Consultation Response from KC Waste Strategy(Refuse & Recycling)
2021/94280 land at, Lady Ann Road, Soothill, Batley, WF17 0PY
Erection of 67 dwellings with associated works
Date Responded:04/05/22
Responding Officer: Mike Hibbert
Responding Ref: WPN 21 029
NOTES/COMMENTS:

PROPOSED SITE PLAN

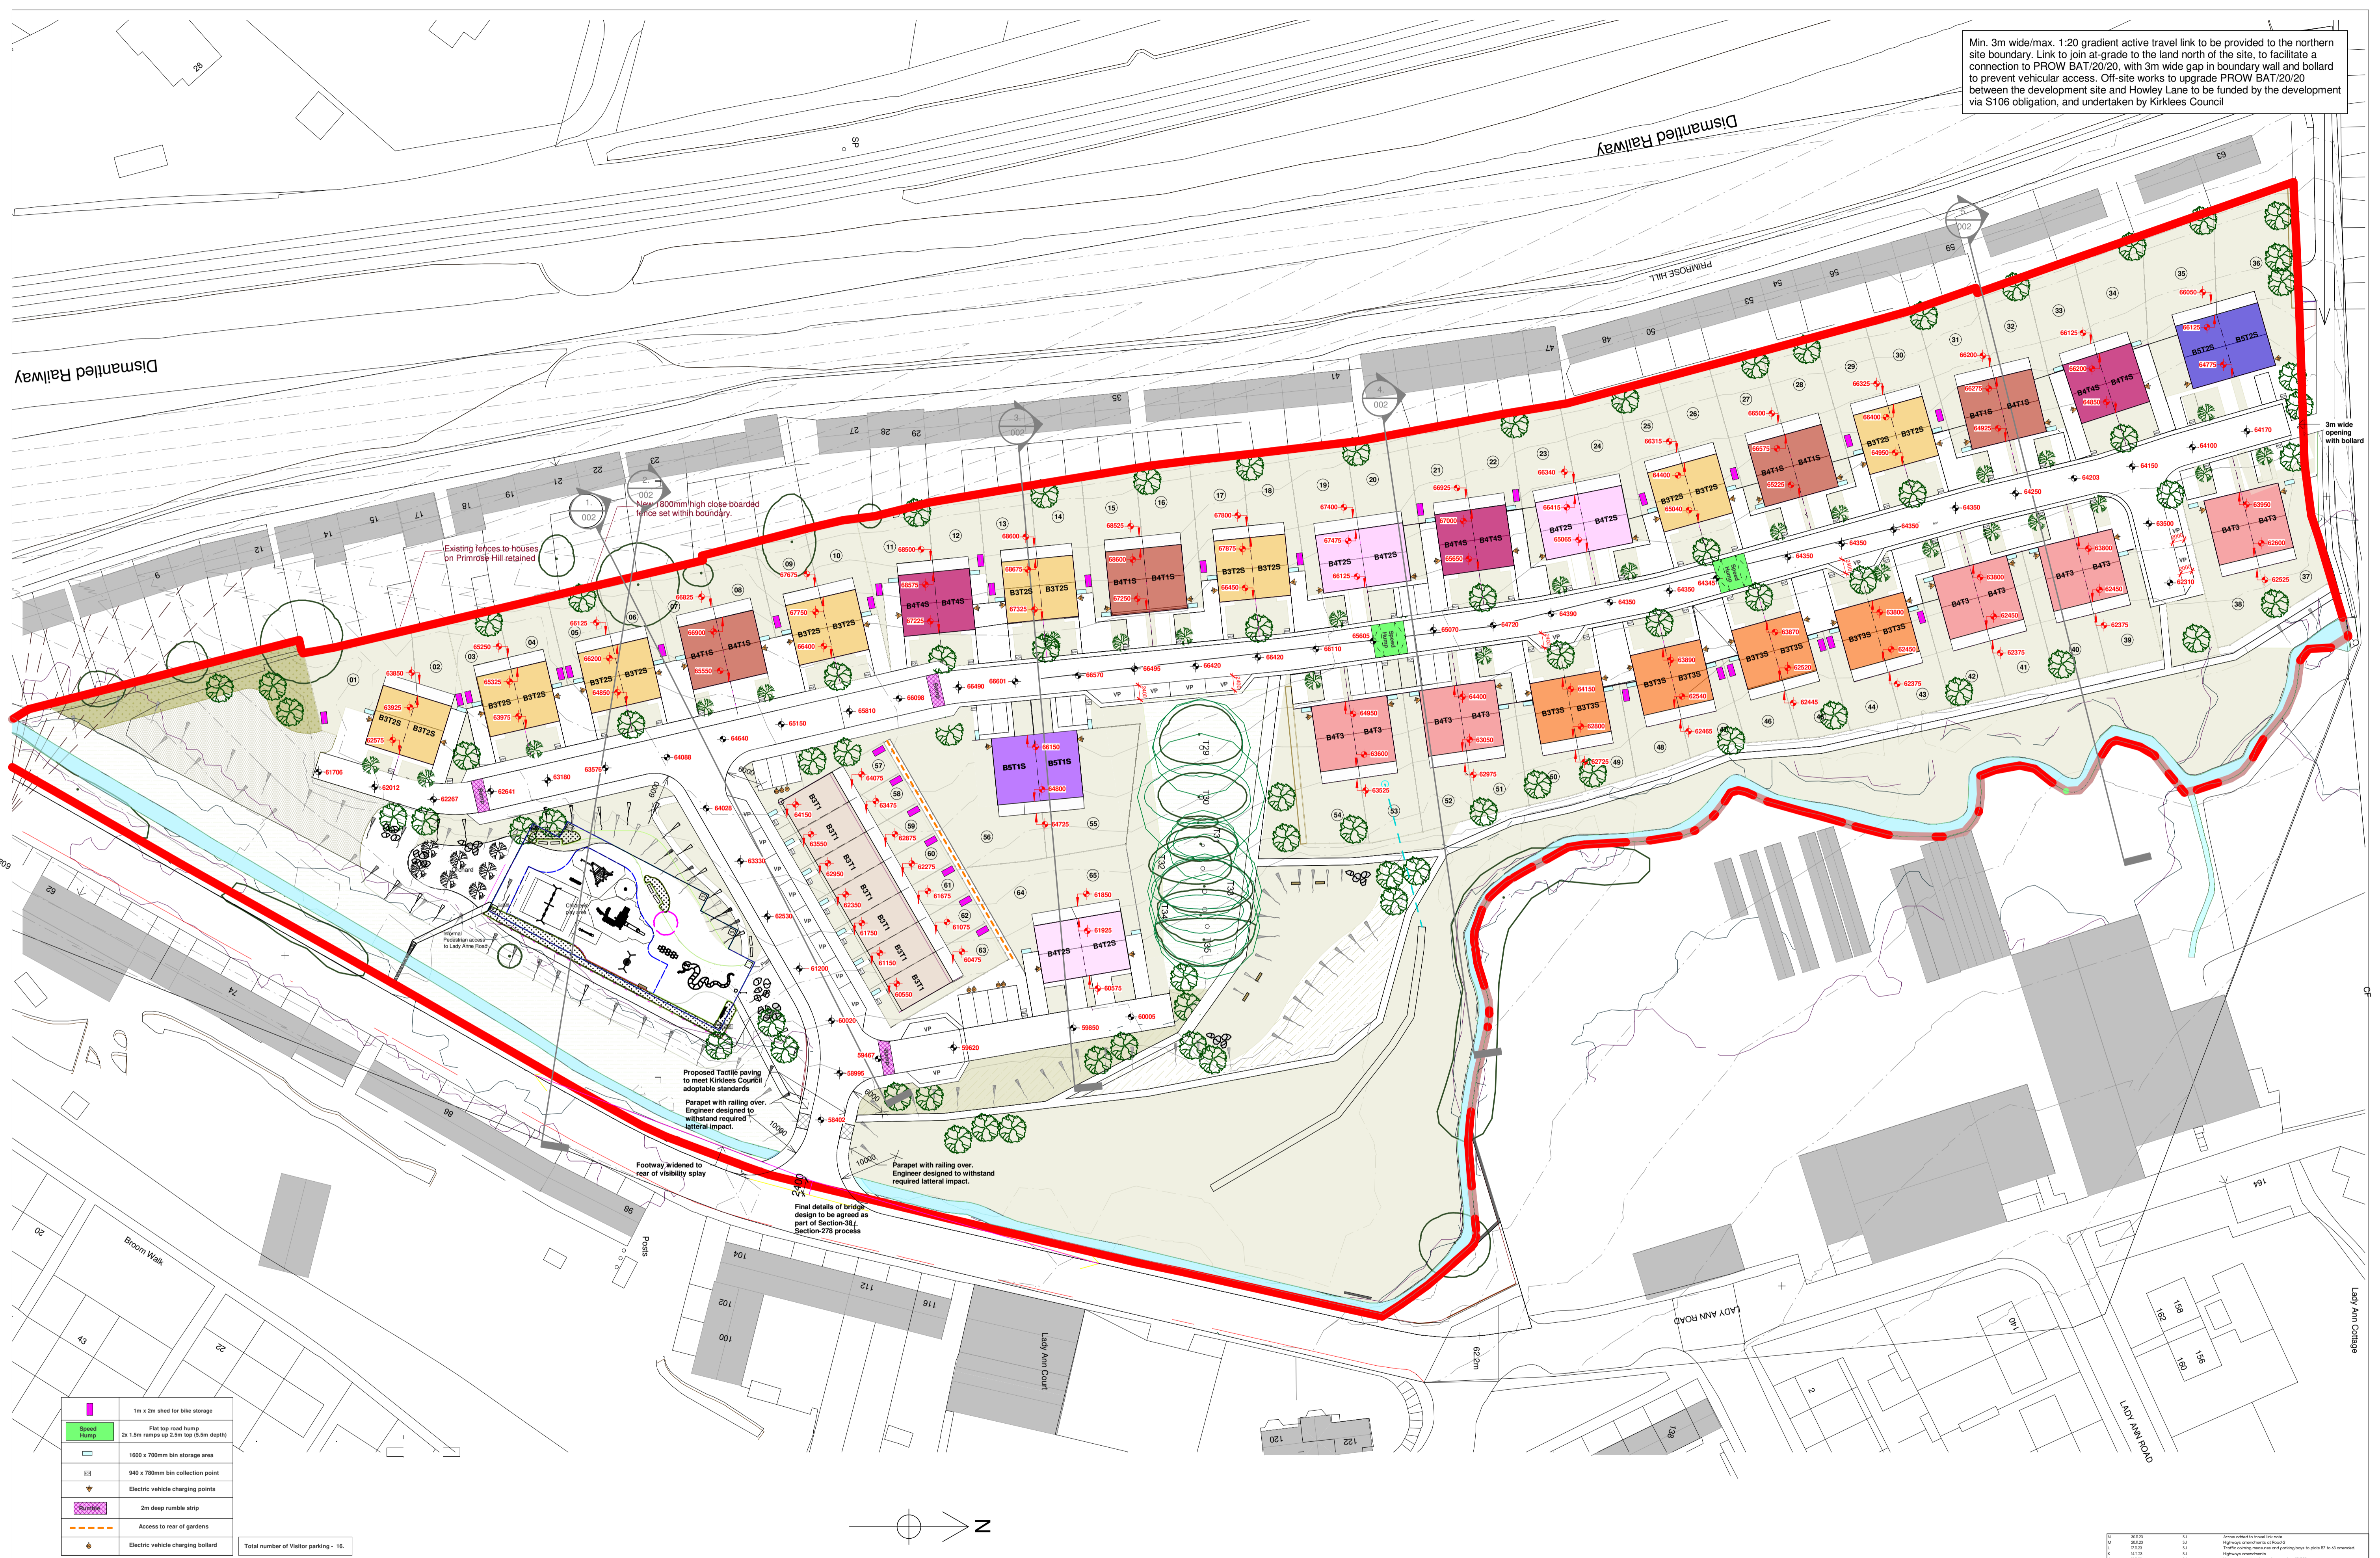
- The proposed site plan ref 10703-SELF-P-XX-DR-A-002 dated October 2021 indicates the location of bin stores for the plots on site. It is welcomed that this design has addressed comments raised in consultation WPN20-052 that related to application 2020/93071.
- The site plan shows provision of storage of 3x 240Ltr wheeliebins for each plot. Additional details are requested relating to the size, design, screening materials and construction of bin stores showing compliance with guidance in the design guide.
- The Authority welcomes the provision of Bin Collection Points for plots 1&2, 32-36 and 70&71 so avoiding the need of RCV entry onto private drives.
- Where there are gateways between bin stores and the highway, the gates need to be wide enough to ensure unobstructed passage through with a wheeliebin.

- The site layout plan shows a turning head between 29 to 31 and opposite plot 67. A turning head without appropriate dimensions would require an RCV to have to reverse either in or out of the development that is not acceptable.
- Angular road shapes such as that shown in the turning head for plots 63 to 71 present difficulties for street cleaning and are a common area for litter and dirt to accumulate. This needs to be properly considered in any detailed proposals.
- Consideration must be given to the process of waste collection for properties that are occupied before the whole site is complete. Temporary measures may be required to allow waste to be stored/presented at an accessible location adjacent to the nearest adopted highway. The Authority will not enter construction sites for the purpose of domestic waste collection. A pre-occupation condition will be required to address this.
